Subject: Birriwa Solar Farm (SSD – 29508870) – Response to Submissions (RTS) & Amendment Report

Attachment A

Detailed advice to DPE Planning & Assessment regarding the Response to Submissions (RTS) & Amendment Report

Birriwa Solar and BESS Project  
Amendment Report  
Bushfire Assessment Report  
Figure 1.3

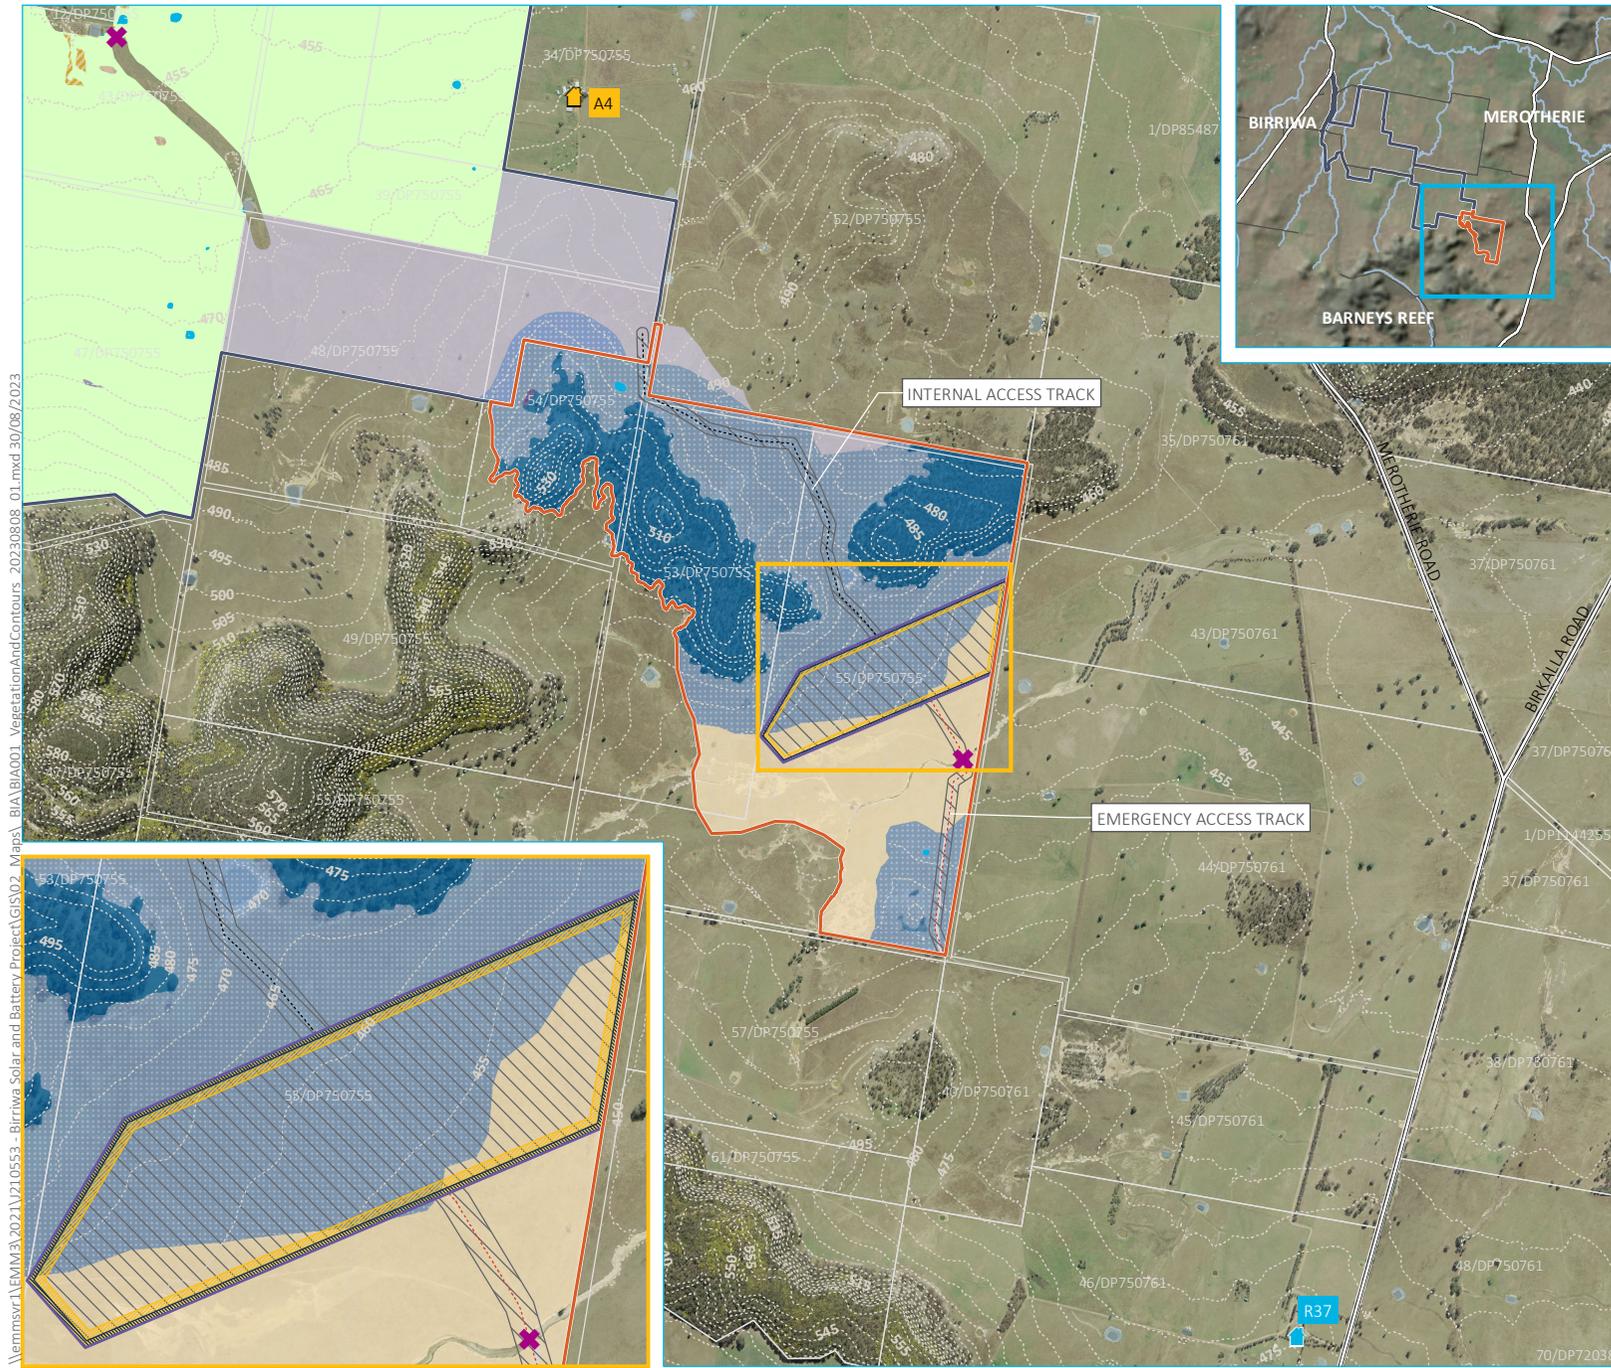
A third order stream runs through the project area that is being used for the temporary accommodation facility. Based on Figure 1.3 of the Amendment report, it appears that a potential crossing may be built over it.

The proponent should ensure works within waterfront land (40m of a watercourse) are conducted in accordance with the Guidelines for Controlled Activities on Waterfront Land available at: <https://water.dpie.nsw.gov.au/licensing-and-trade/controlled-activity-approvals/guidelines>.
